Submission Form

Epping to Thornleigh Third Track Proposal. Application number SSI 5132.

Name(s): John Piper and Margaret Piper

Figure S.6 Cross-section and elevation - New Cheltenham Station concourse building (see also S.5 for artist's impression)

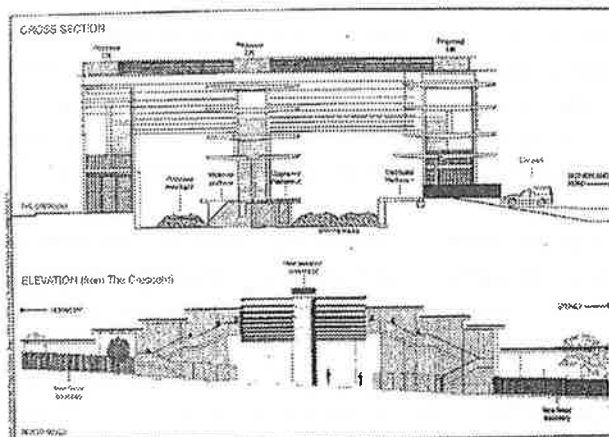
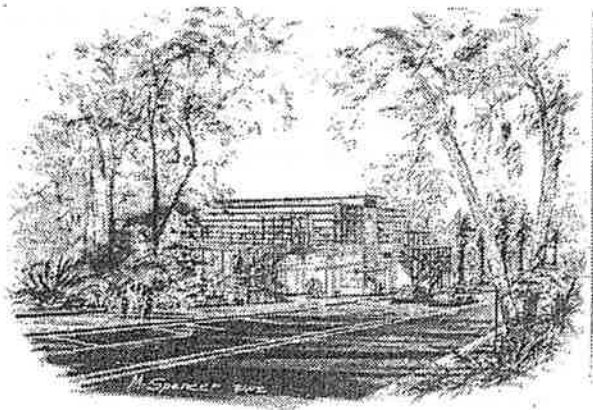
- The proposed redevelopment of Cheltenham Station shows no regard for the HCA. The visual impact of the proposed 13m high glass and steel concourse is totally unacceptable in this HCA.
